Engineers Comments Regarding Surface Water Drainage

Application Reference:	P/59/25/DOC	Reviewer Reference:	ADC/EXT2/D2134/80
Planning Officer:	Amber Willard	Date of Review:	13.11.2025
Site Name:	Sefter Farm Pagham Road Pagham PO21 3PX		
Application Description:	Approval of details reserved by condition imposed under reference P/117/21/PL relating to condition number 7 - surface water drainage scheme.		
Assessment Number:	2 of 2

TITLE Existing Site Areas Plan			
SCALE 1:1,000 @ A3		PROJECT No. 24019	
REPORT TYPE DS		DRG. No. 07

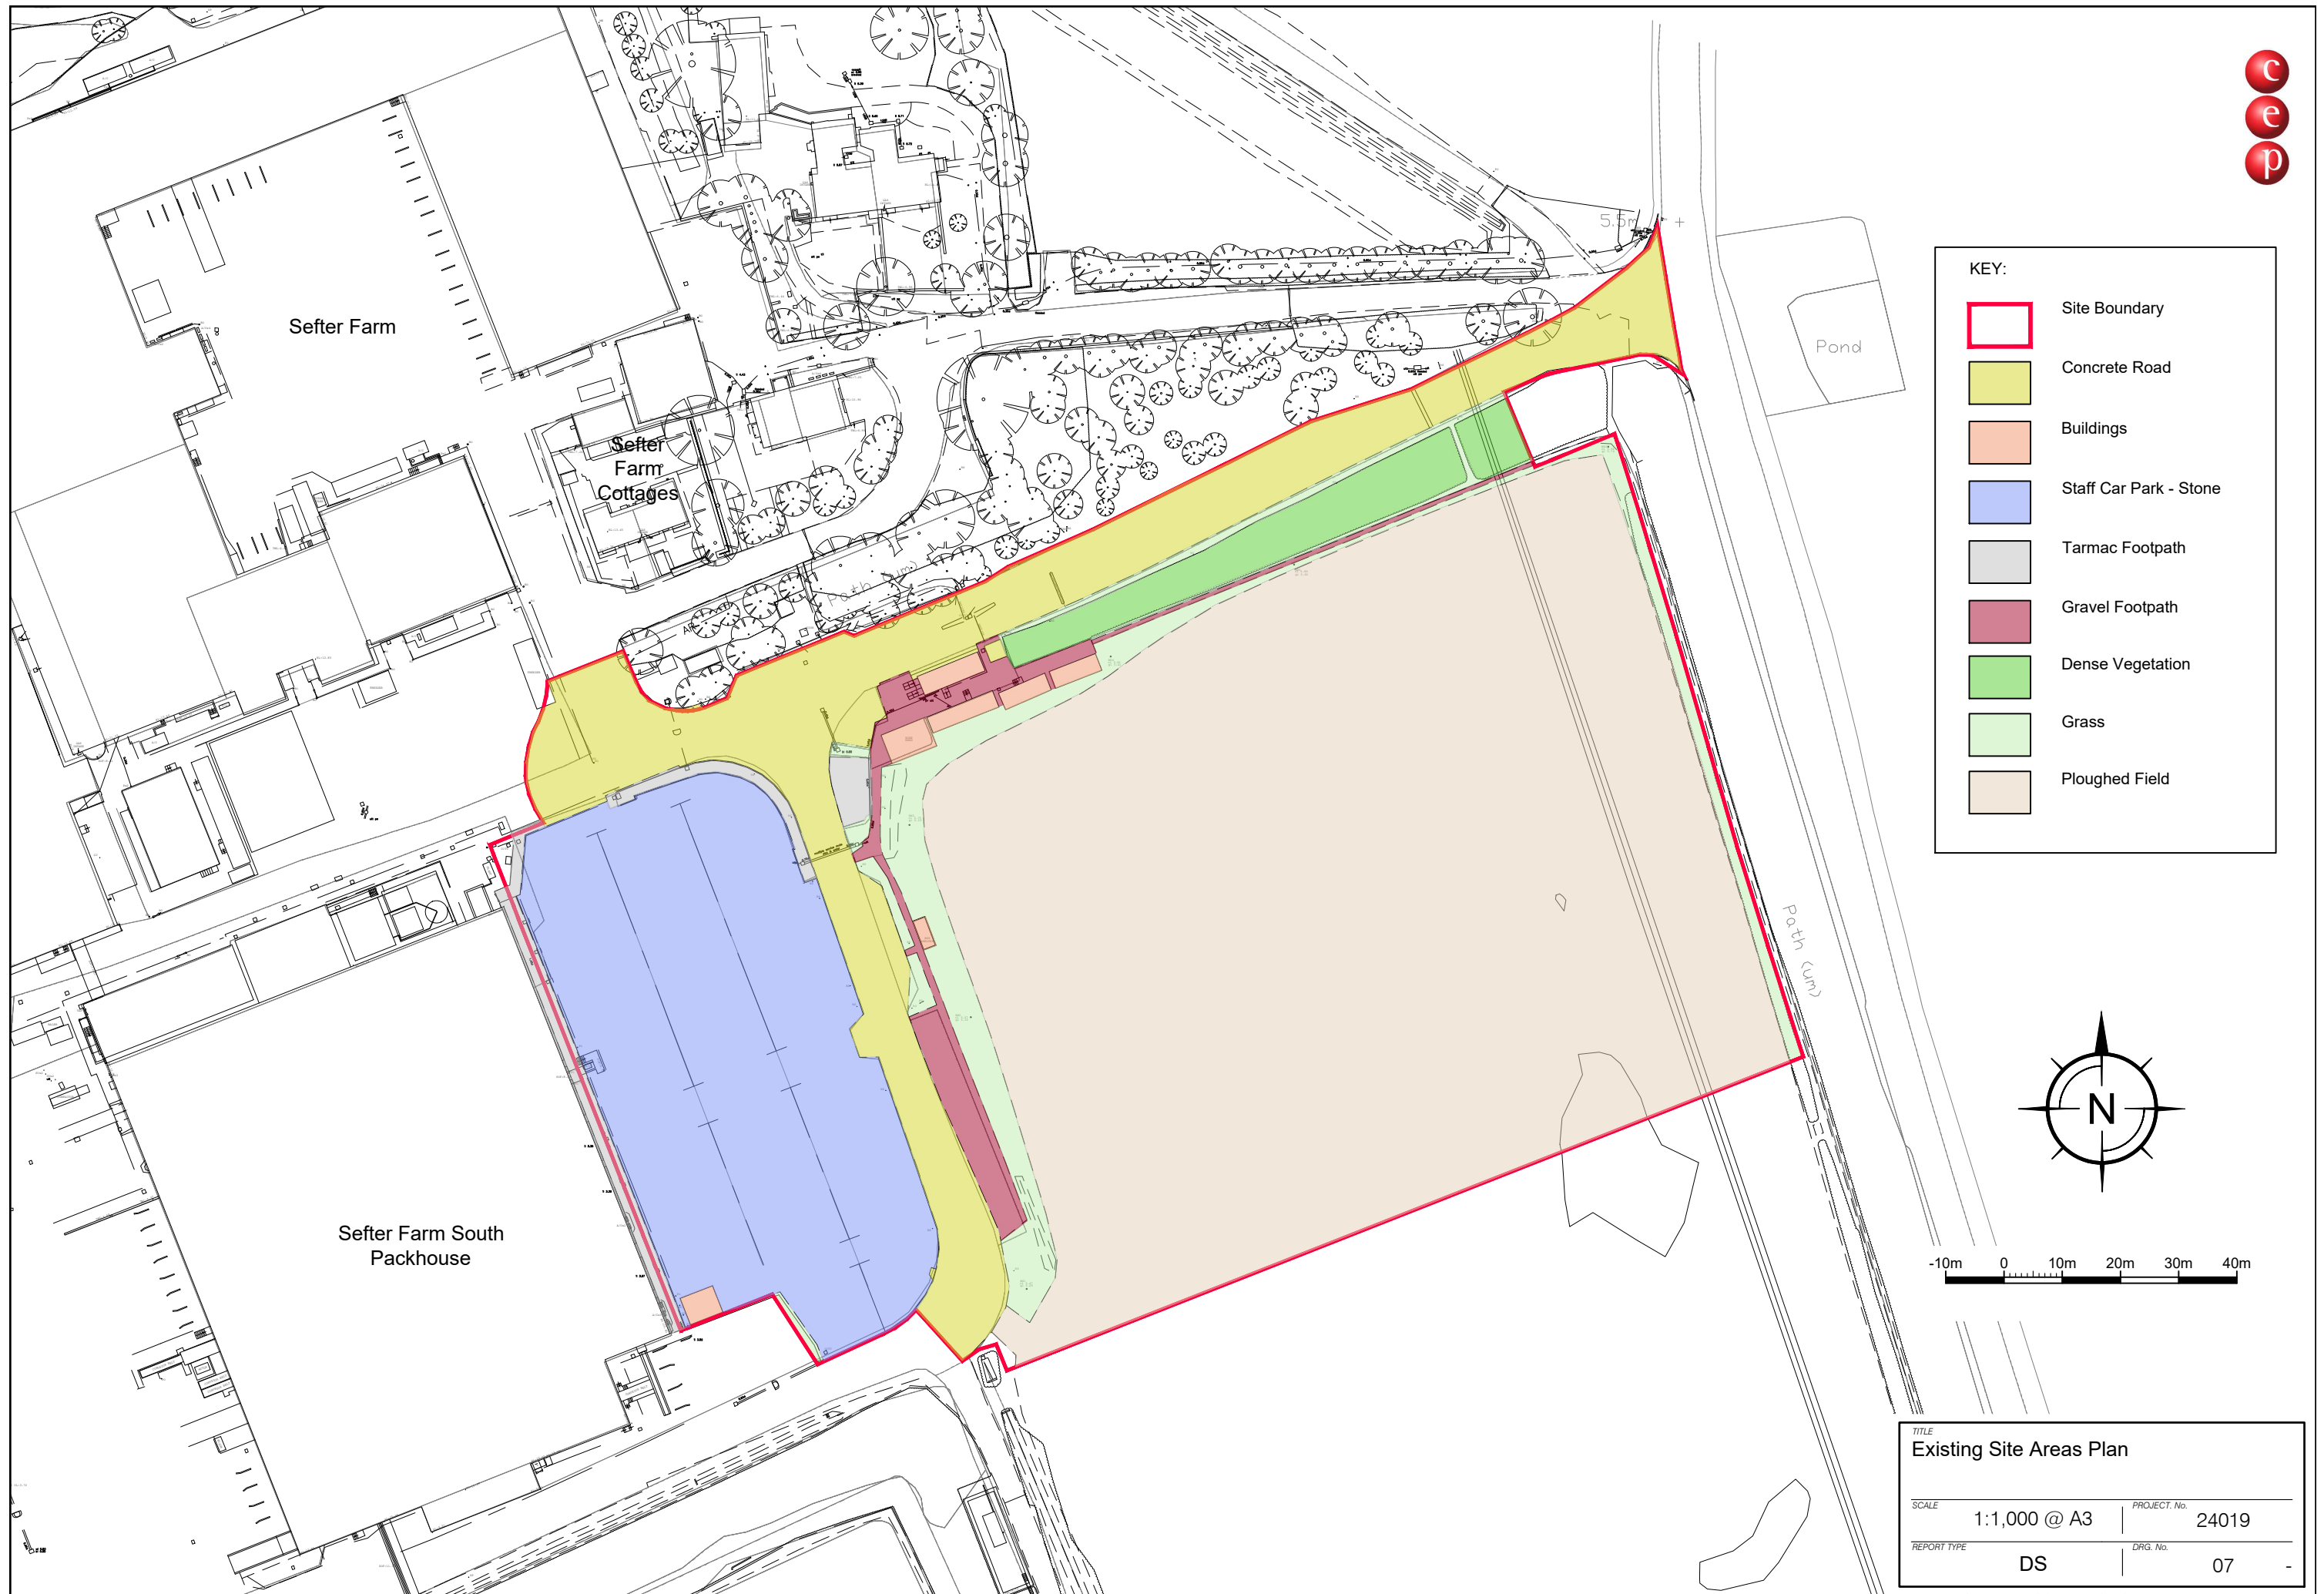
3.	The drainage statement include 'proposed site layout and drained areas plan 03' which is accepted. However for completeness please provide similar drawing denoting the 'existing layout'	It is unclear why this is being requested. The proposed external surface is being increased by the development proposals.	Noted. Plan 07 is sufficient. Comment closed.

and impermeable/semipermeable areas.	The design is based on those increased areas. Pre development runoff calculations are based on greenfield equivalent flows not the pre developed impermeable areas. This request is of no relevance to the site going forward and does not provide any useful information relating either to the approved planning permission or to the detailed design of the surface water drainage system. We attach Plan 07 noting the current layout of the site and the current surfaces.			
--	---	---	--	--	--

CLIENT	Barfoots Of Botley
PROJECT	Setfer Farm East
TITLE	Site Layout - Surface Finishes - Sheet 1

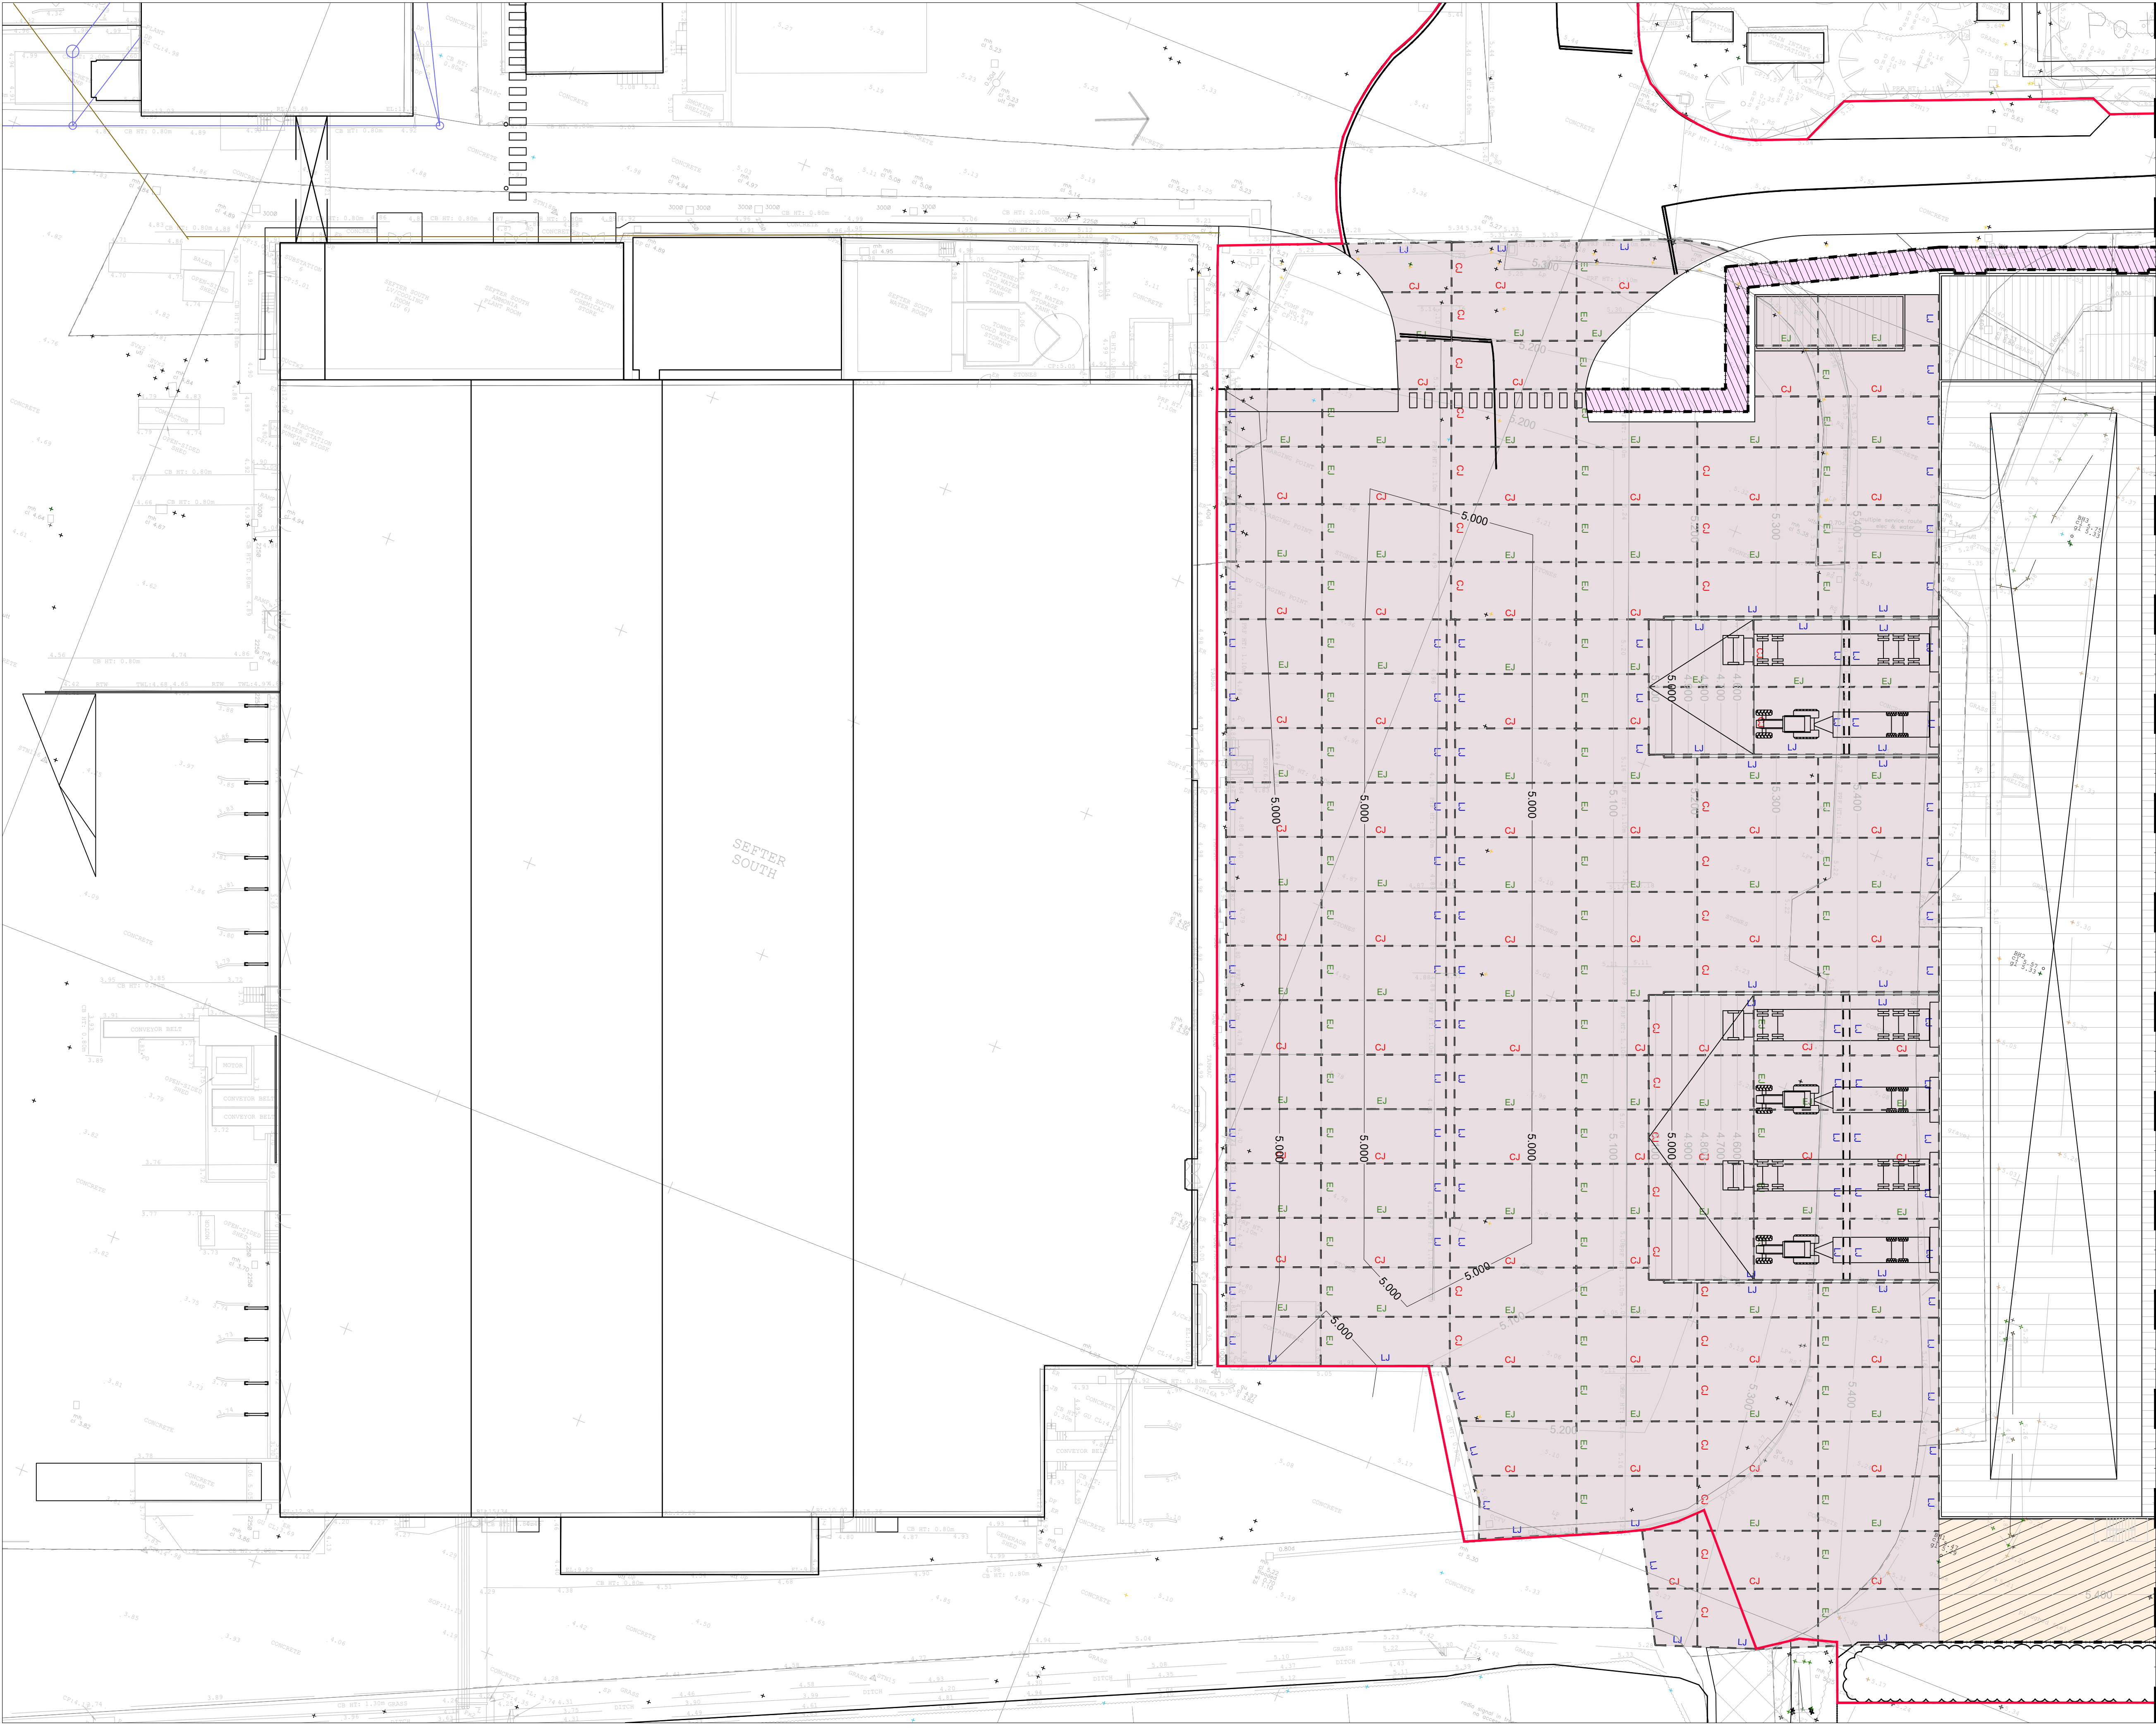
9.	Whilst the proposed yard and permeable parking are proposed to be laid very flat, the site sections nor surface finishes highlight any boundary kerbs/edging which may have a role in controlling run-off, please confirm.	The permeable paving is to be constructed over voided subbase which by definition is constructed below ground level. No edgings are required to retain below ground storage, impermeable membrane is noted on the Construction Details Surface Finishes Drawing 501 submitted with the application and copy attached. The membrane is shown at the base and the edges of the permeable stone to retain the surface water within the system below ground. There are also edgings shown where relevant on the surface finishes detailed design drawings submitted with the Discharge of Conditions application.	Noted, however the edge restraint/support must be fit for purpose i.e vehicular loading along the edge. The construction details on 501 must be updated to demonstrate how the edging will be installed to the outer edges permeable pavement. Comment outstanding.

11.	Permeable pavement construction details must be updated to qualify kerbs/edgings.	As previously noted: There are edgings shown where relevant on the surface finishes detailed design drawings submitted with the Discharge of Conditions application. Please see Surface Finishes Drawings 24019-401 and 24019-402	Please see response to comment 9 above. Comment outstanding.

Please see Surface Finishes Drawings 24019-401 and 24019-402, copies attached.			
10.	Please provide supplier details/quotes for all flow control devices/sump requirements.	All flow controls are orifice plates. These can be sourced from a multitude of suppliers. There are no hydroborates or bespoke flow control devices propose on this scheme. Flow control manhole construction details have been added to Drawing 511 C, copy attached	National Standards advises <i>'3.22 Where the peak allowable discharge rate requires flow controls with orifices (or equivalent) with a diameter of less than 50mm, the flow control shall be robustly protected from blockage risks. Regardless of this, the risk of blockage for all flow controls shall be assessed and mitigated against'</i> The bespoke flow control details on drawing 511, with 40mm size are a relaxation to the above clause and therefore the designer must clarify on how the risk of block has been assessed and mitigated. This may also require further clarification for maintenance. Comment outstanding.
